Rezoning Transportation Analysis

Petition Number: 2020-067

General Location Identifier: Tax ID 09505544

Date	Description
05-18-20	First Review
06-25-20	Second Review (TV)
08-25-20	Third review

RZ-3

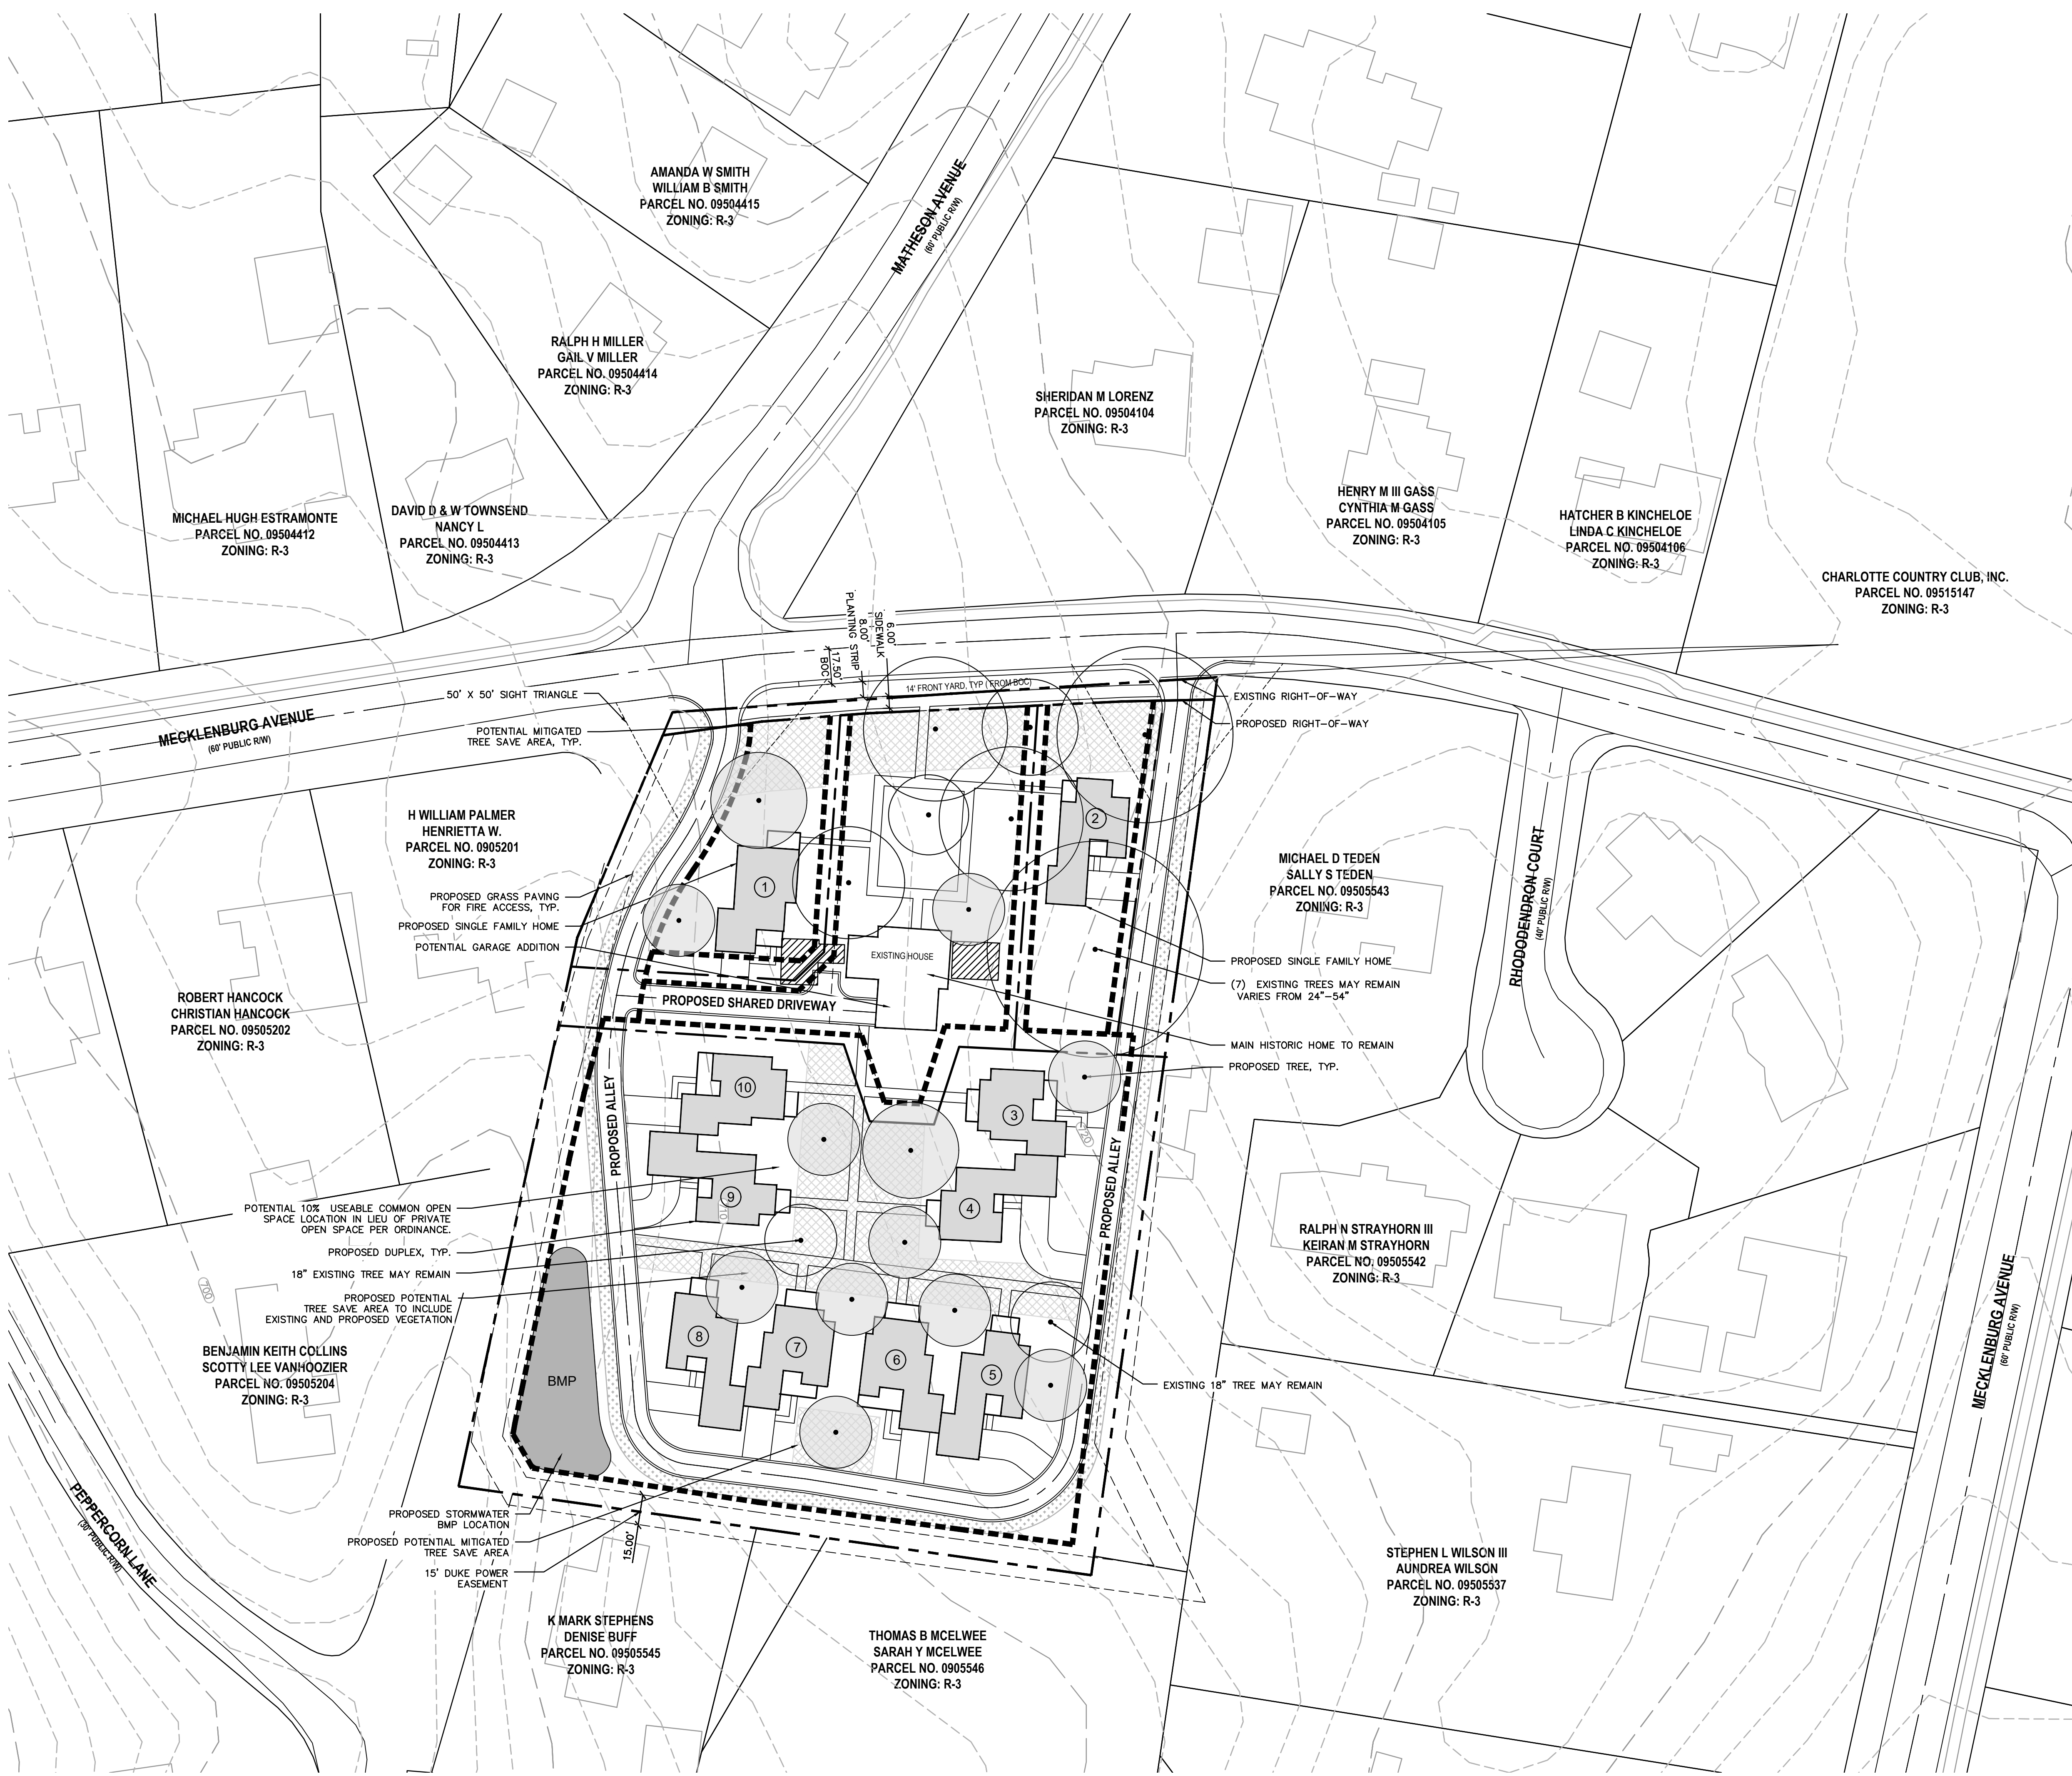
- The petitioner should revise the site plan and conditional note(s) to commit to constructing a public street, Matheson Avenue south of Mecklenburg Avenue, as a Local Residential Medium with an 8-foot planting strip, and 6-foot sidewalk per Chapter 20 Subdivision ordinance.

Reference (CLDSM standard detail U-03A) for street typical.
